From: [Barb Davidson](#)
To: [CDS User](#); [Jeremiah Cromie](#)
Subject: Sparks Park Variance parcel #778834
Date: Tuesday, May 2, 2023 11:08:43 AM

CDS is requesting comments on the following Variance and associated SEPA application (SE-23-00010): VA-23-00003 Sparks Park.

RE: Sparks Park Variance (VA-23-00003)

RE: WDFW Comments on VA-23-00003 Sparks Park

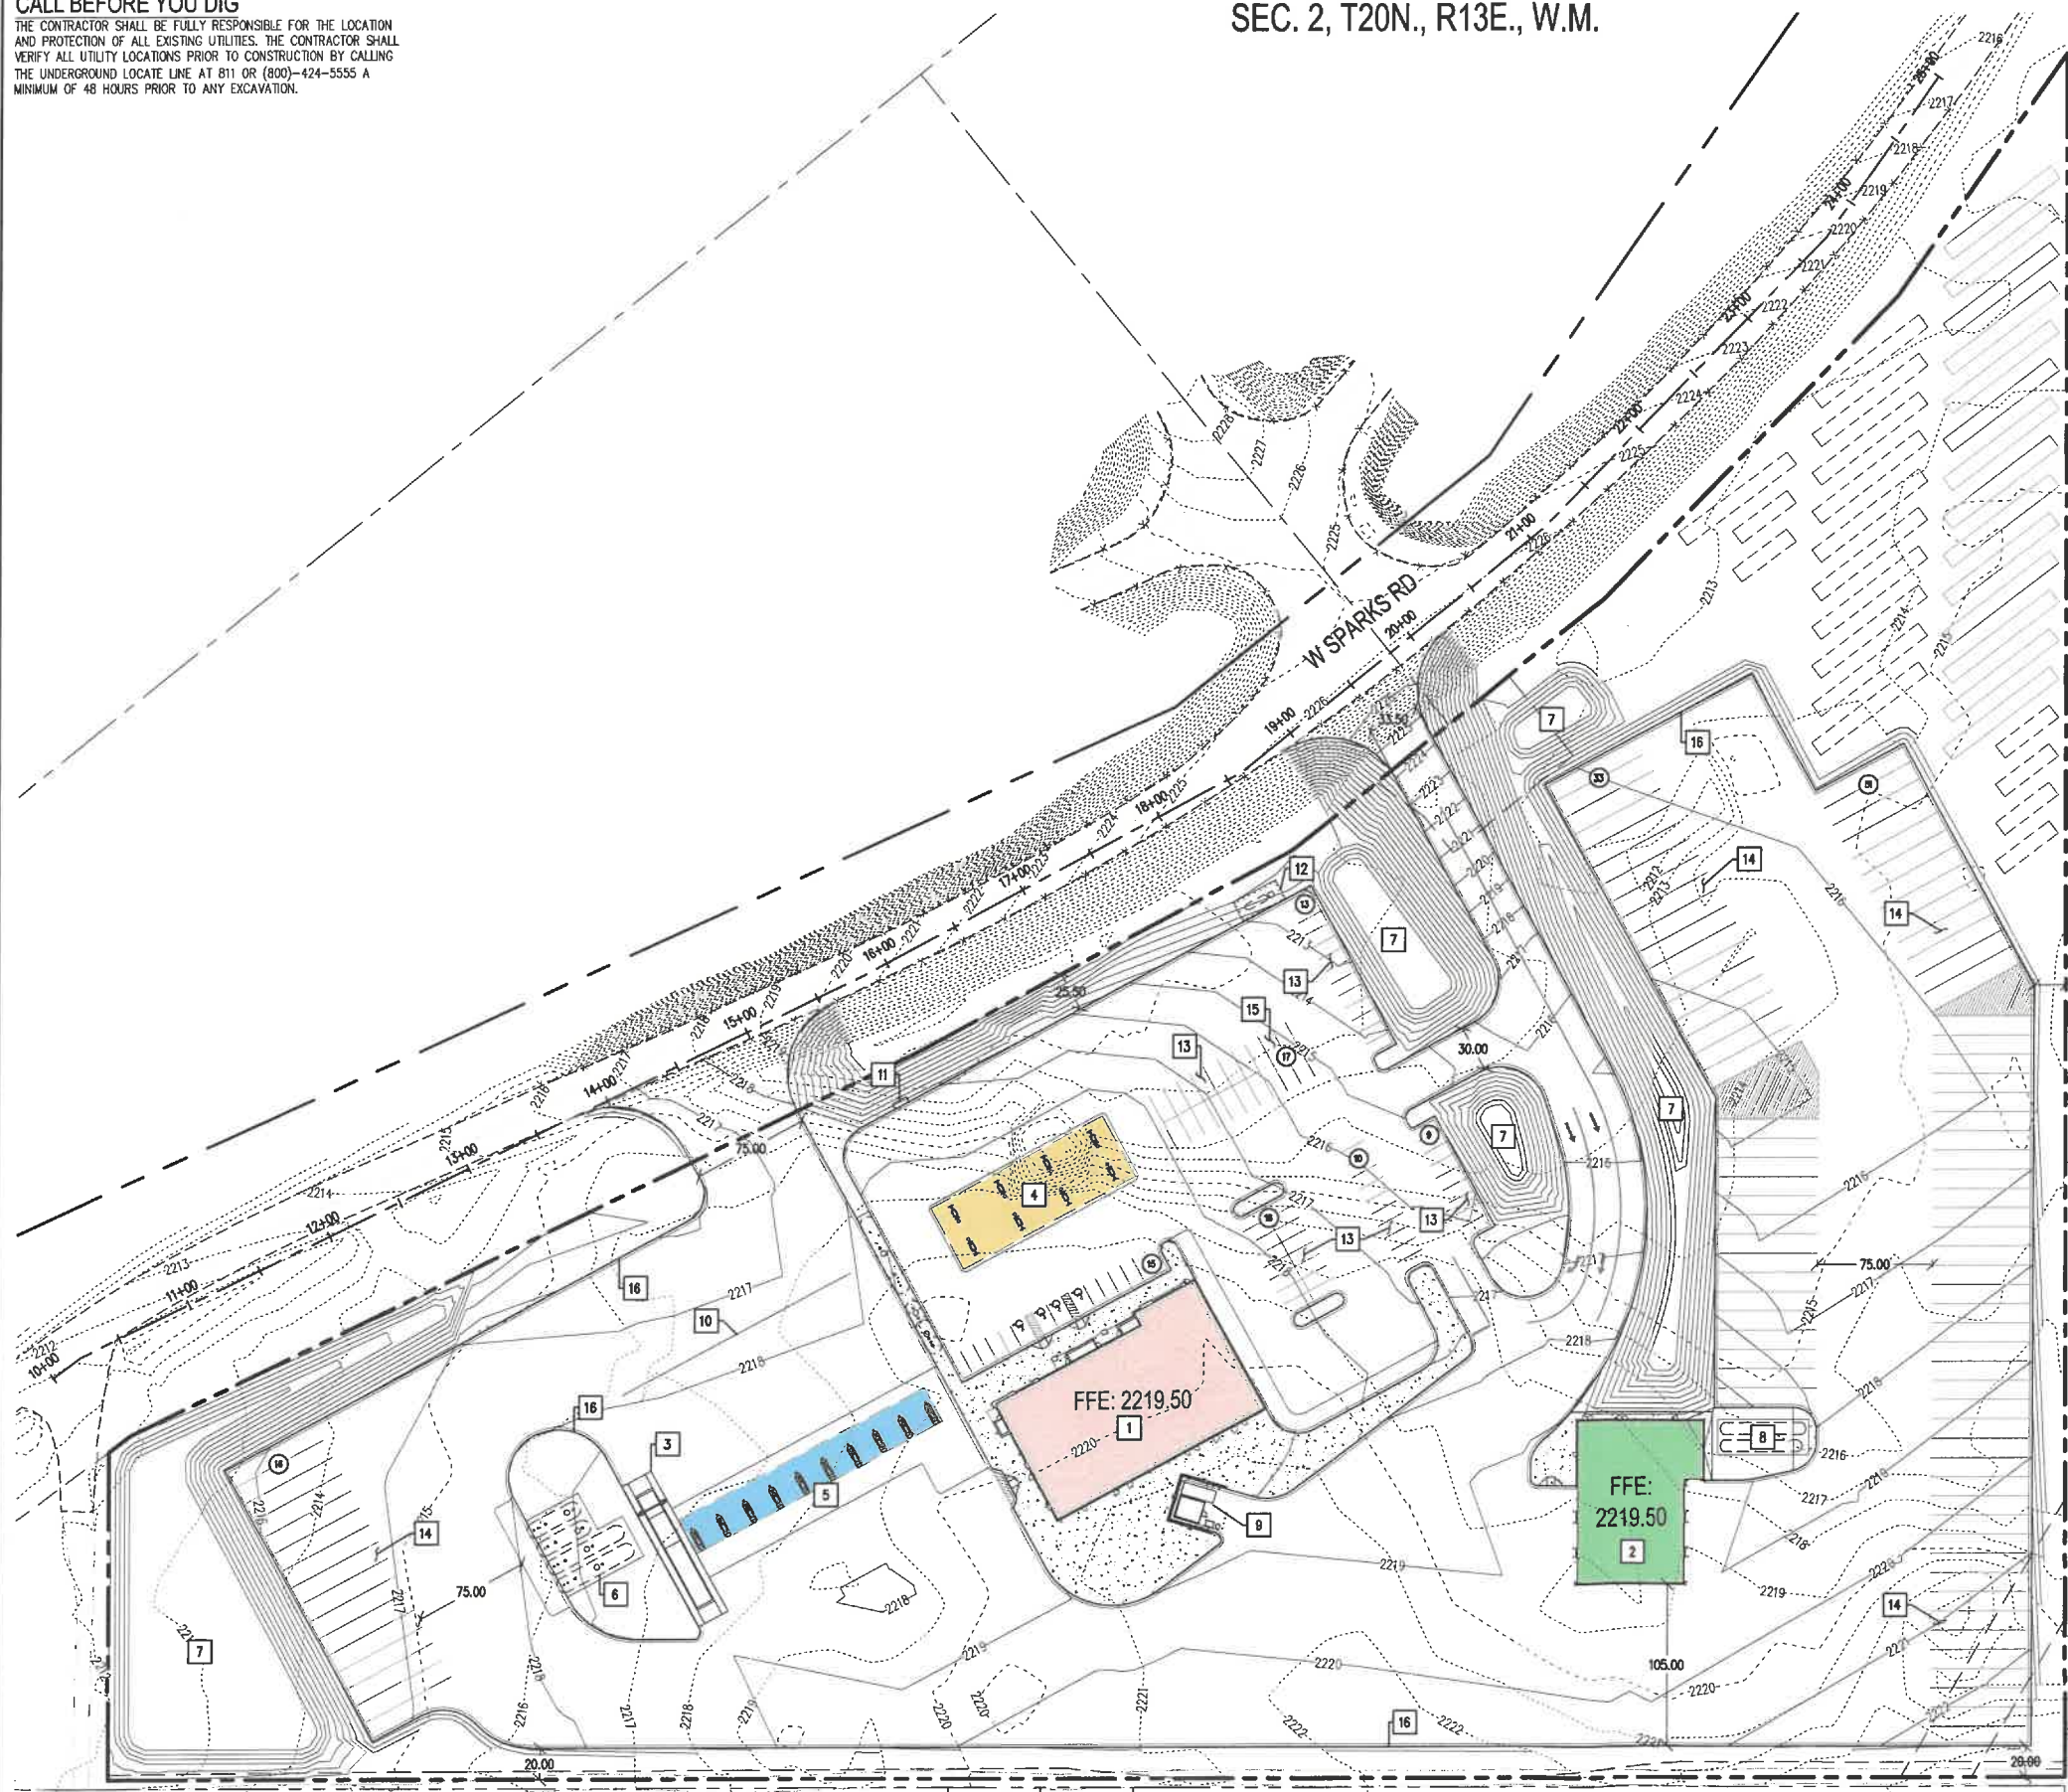
The attached Preliminary Site Plan does not clearly identify Septic tank, drain field and replacement area. The document is almost impossible to read due to the poor quality. It is difficult to tell if the additional items required by the Site Plan submittal are included in the submitted document. Without clarity it is difficult if not impossible to make constructive comments on the site plan for this document.
